Application for a non-material amendment following a grant of planning permission.

ERECTION OF SINGLE STOREY SIDE/REAR
EXTENSIONS TO BOTH SIDES OF BUNGALOW

2017/0775

CHANGING EXTENSION ROOF'S FROM GABLES TO
HIPS

Drawing Title
 PROPOSALS

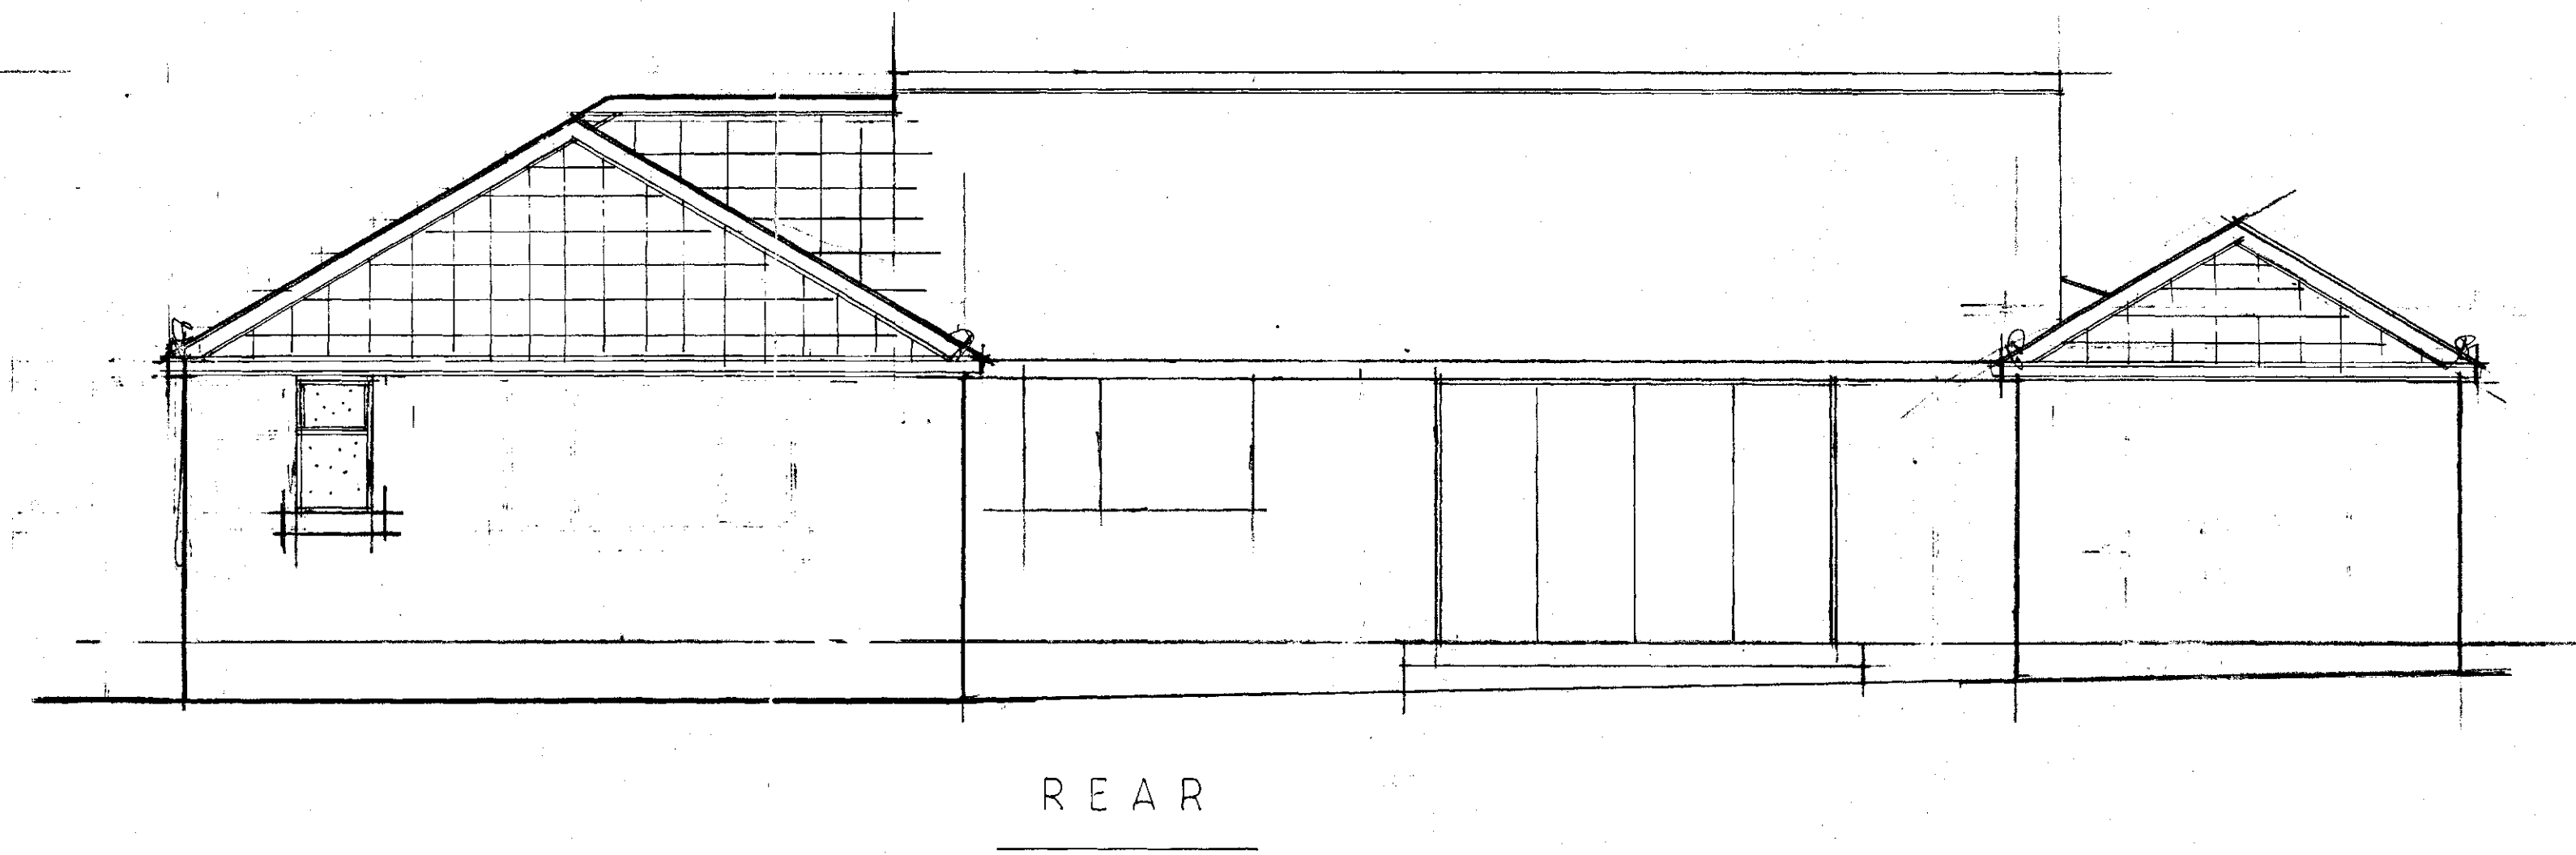
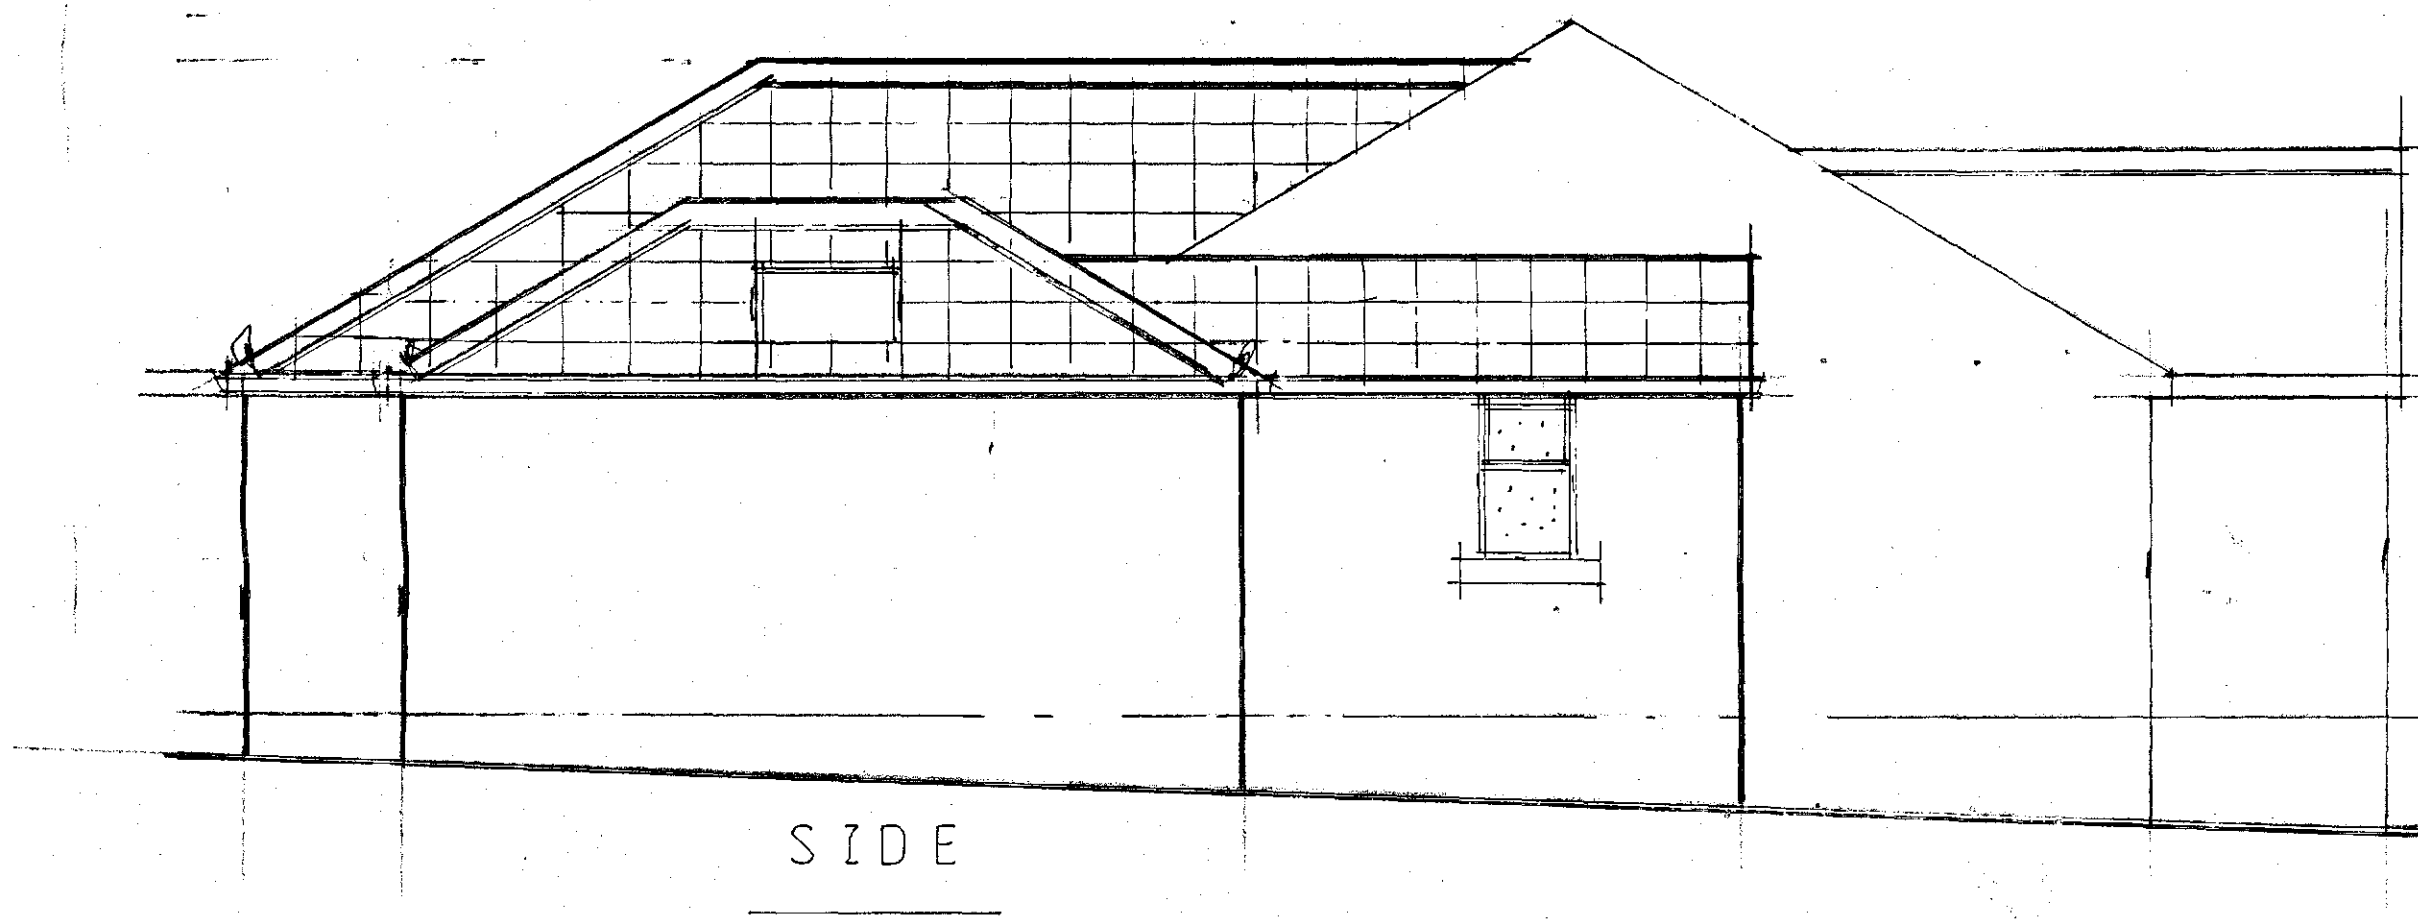
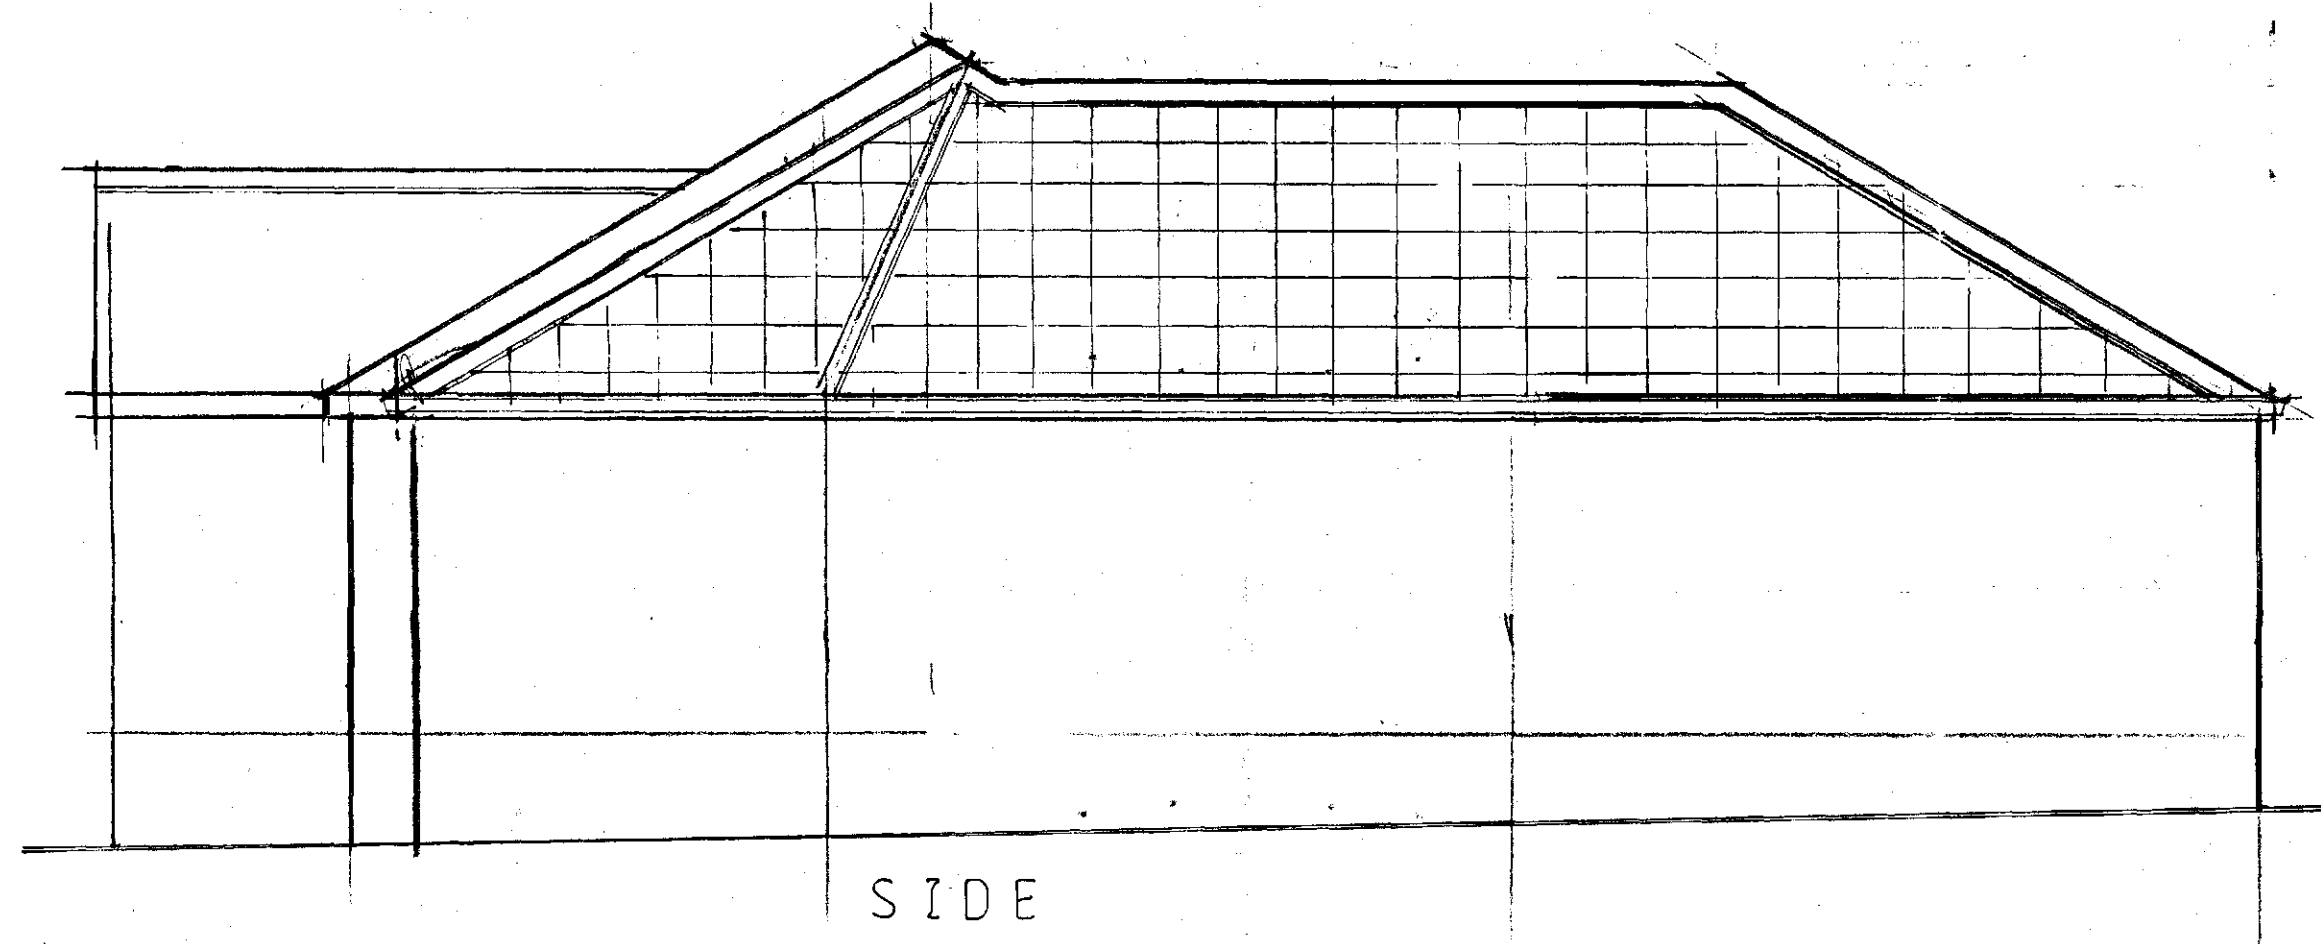
17/77/B rev A 17/77/C rev A

17/77/B rev B 17/77/C rev B
